# CITY OF ALBUQUERQUE

**Re: Maverik, Wyoming & Constitution**  
1401 & 1415 Wyoming Blvd NE, 87112  
**30-Day Temporary Certificate of Occupancy**  
**Transportation Development Final Inspection**  
Engineer's/Architect's Stamp dated 2-6-19 (J19D049)  
Certification dated 1-8-20

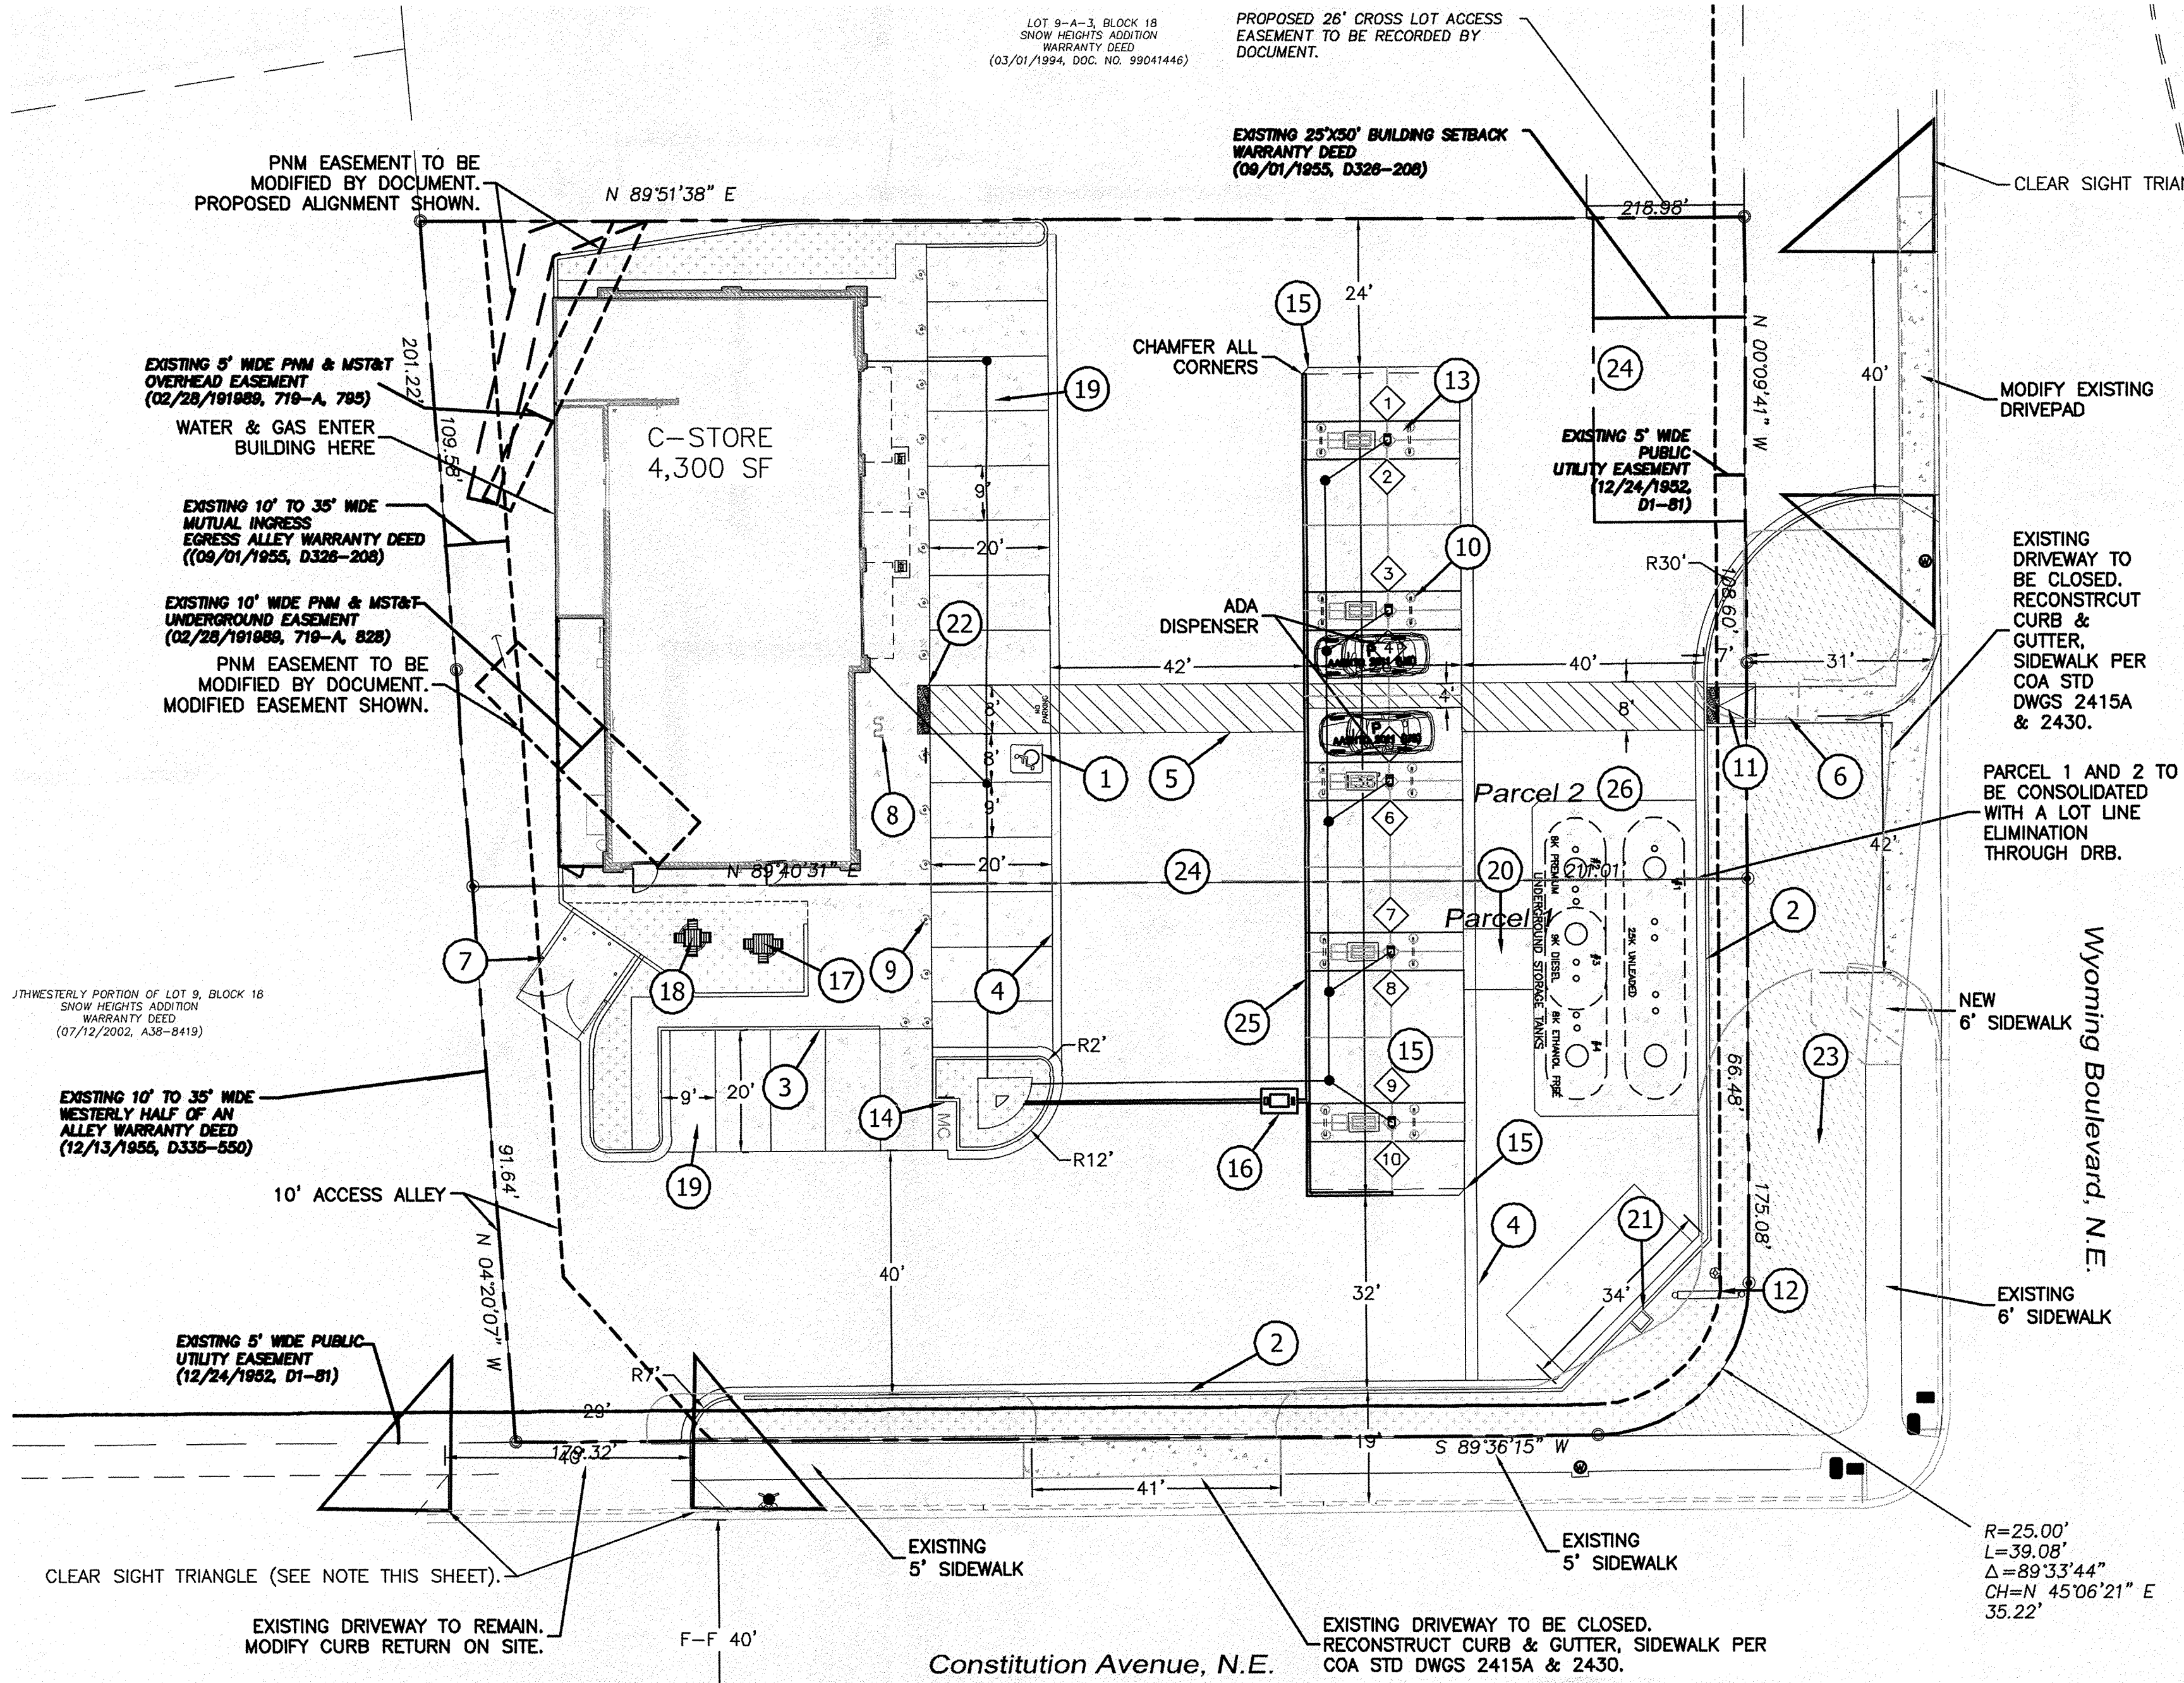
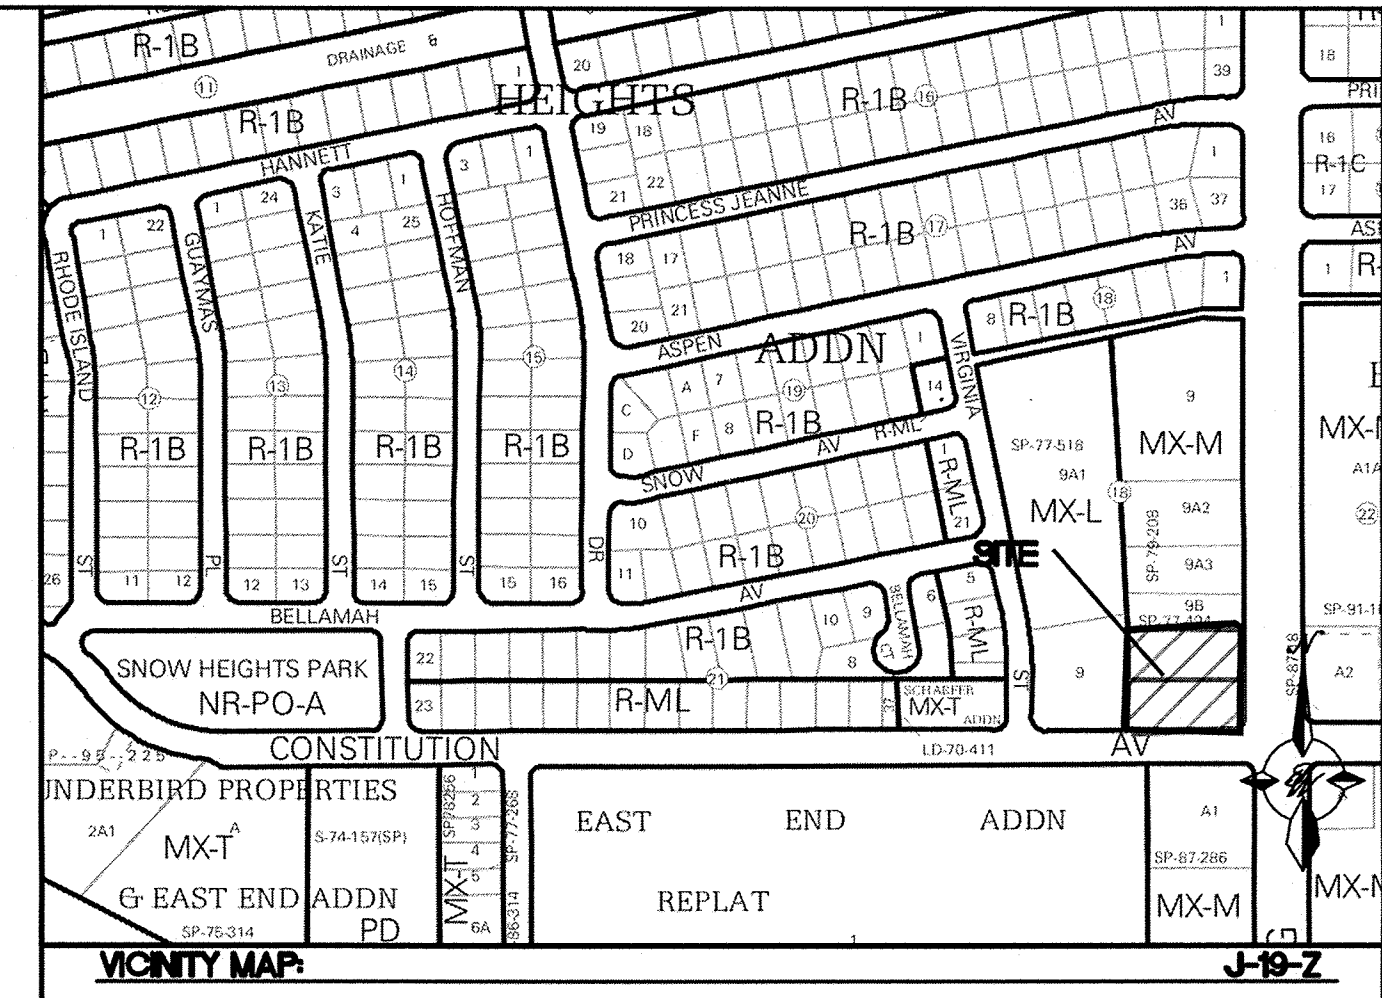
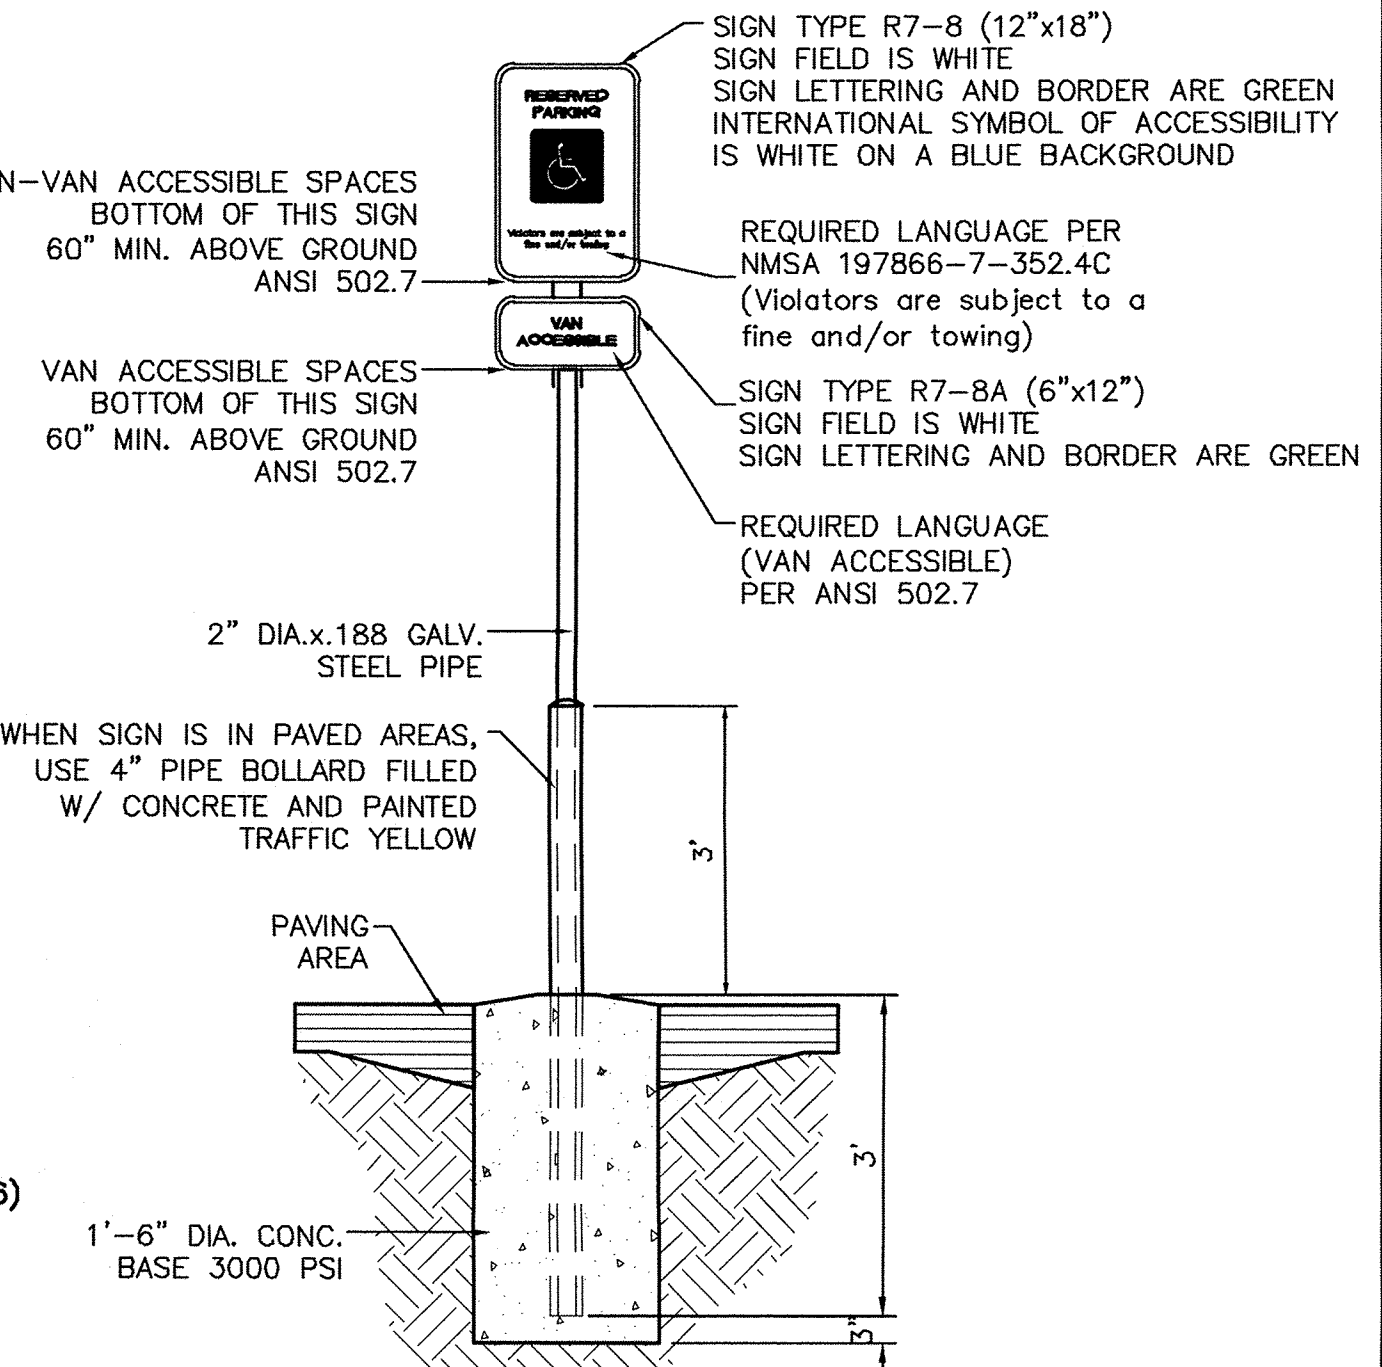
- Please add missing truncated domes (ADA aisle connecting to sidewalk and access off Wyoming)
- Please add parking bumpers to stalls on SW side of building
- A complete Work Order close out package is required.
